Your Ref: OWPC20975
Our Ref: A/158/18/PL 23-11-2018
Please ask for:
Mrs A Gardner

Variation of condition 1 imposed under A/8/18/PL relating to the substitution of approved plan drawings NO ADC 962 04 rev A & 13 rev B for drawings No ADC 962 20 & 21 (ground & first floor plans & roof plan). This application affects the character & appearance of the Angmering Conservation Area.

Land Rear Of 1 To 6 The Cottrells Angmering

Rev	Description	Date
Job Reference		
New House The Cottrells Angmering, BN16 4AF		Client AM Homes Ltd
Drawing Title Ground Floor Plan		Drawing No ADC962/20
Date 23.11.18	Scale 1:100	Dwg Size A3
Plot Style ADC-red	Drawn TOS	Checked AD

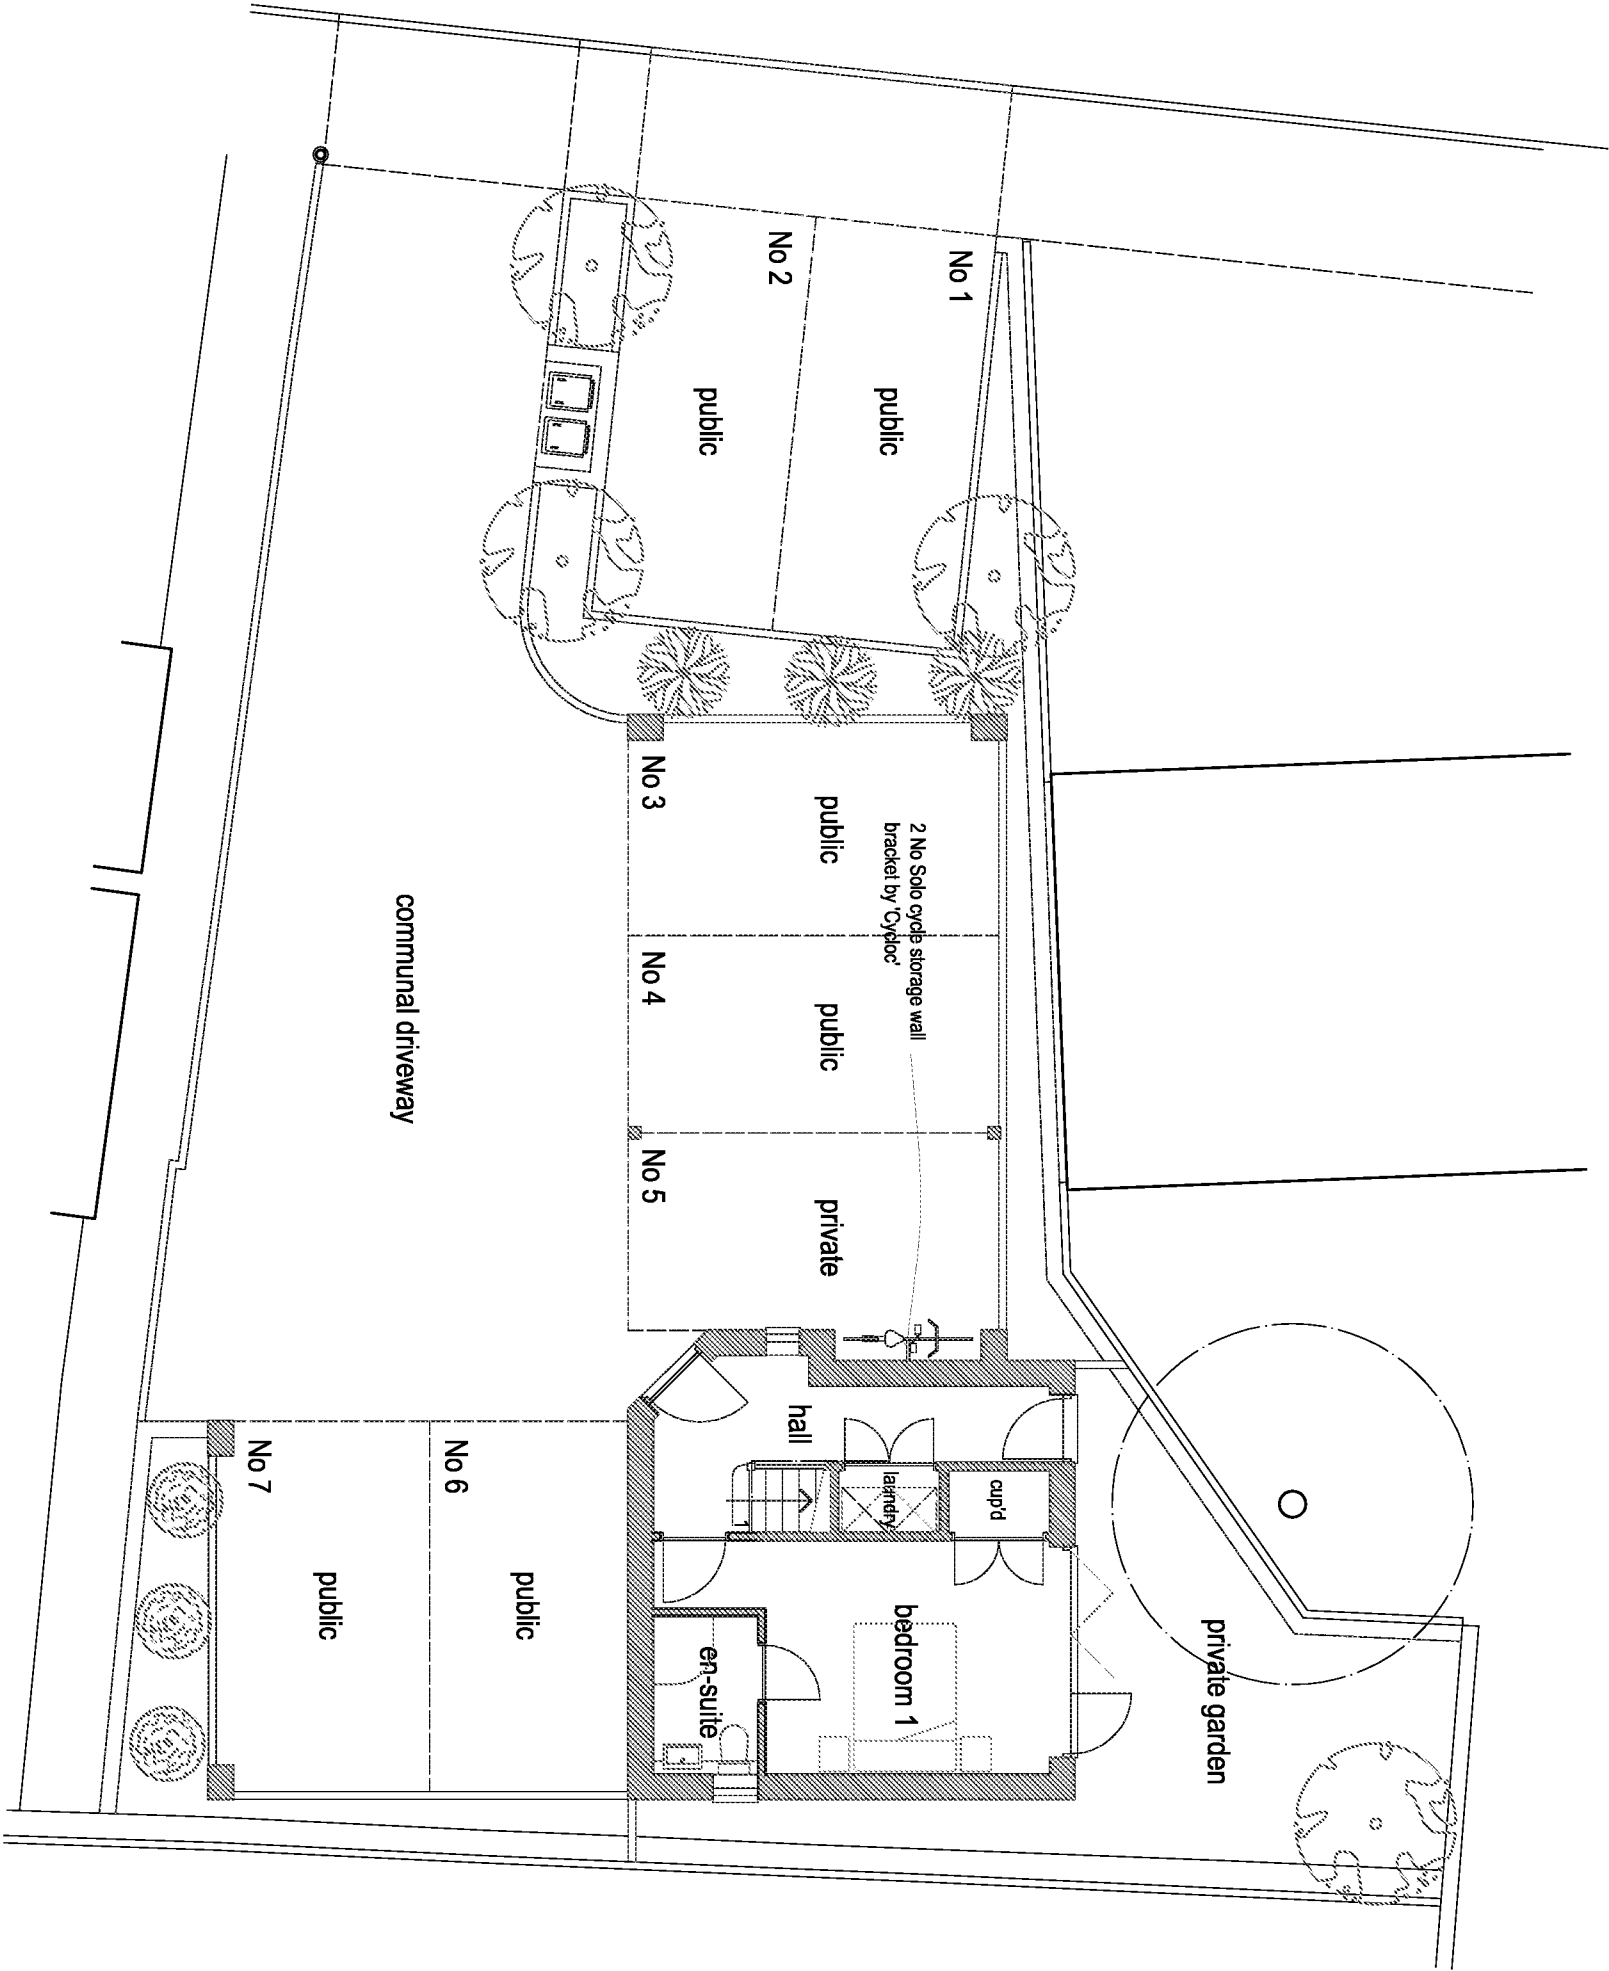
I am writing to object most strongly to the above planning request. Planning permission was granted for this property clearly stating that the kitchen had to be on the ground floor and specifically stating that it would not be a 3 bedroom property as this would significantly increase the likelihood of the property owners having at least 2 cars putting and additional strain on the parking situation in The Cottrells which has already exceeded capacity. Residents currently often have to park in the village or outside the village shops leaving no spaces for customers and thus effecting local businesses. The kitchen was built upstairs despite these planning specifications and an en suite was built in the area designated for the kitchen showing that the plans were never intended to be adhered to. The request that the downstairs kitchen area is now labelled as bedroom 1 is ridiculous as this is the smallest of the 3 possible bedroom spaces. The area now marked as a study is clearly bedroom 2 and this rewording is a blatant attempt to turn the property into 3 bedrooms without applying for planning permission as such knowing that it has already been refused.

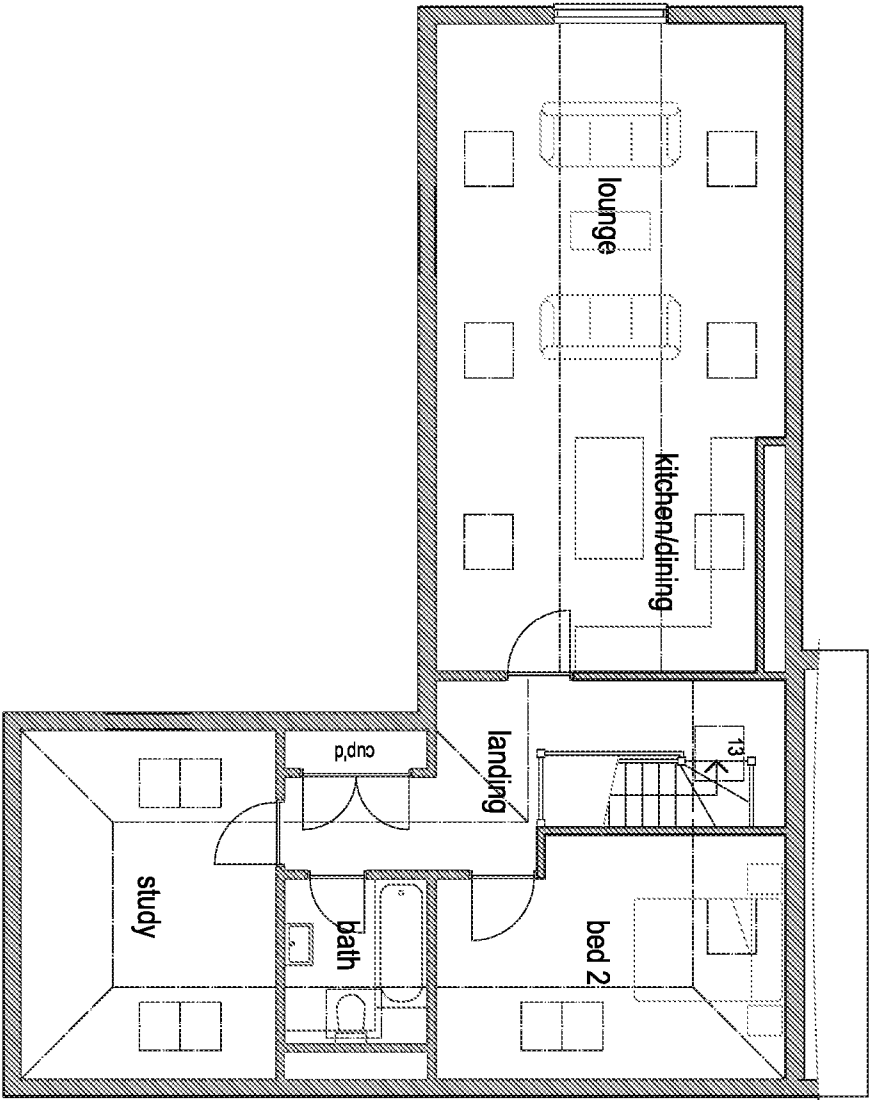
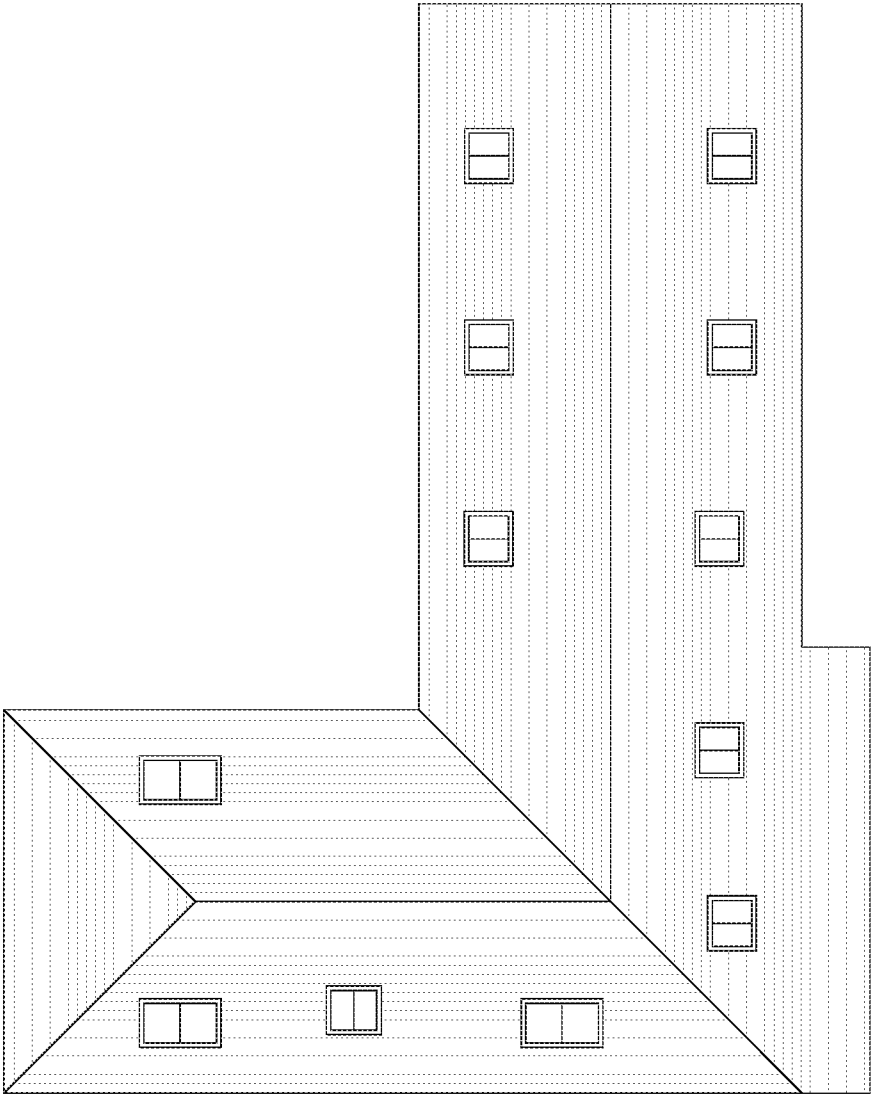
When planning permission was agreed it stated that the windows were emergency roof lights only and would in no way effect the privacy of surrounding houses. They are now fully opening velux windows and are positioned in such a way that our garden is completely overlooked but most worryingly they look directly into my young daughter's bedroom affording her no privacy at all to the point where she will not change in her room. I feel that granting permission for these windows to remain as they are in contradiction to the original agreed plans would be a serious child endangerment issue.
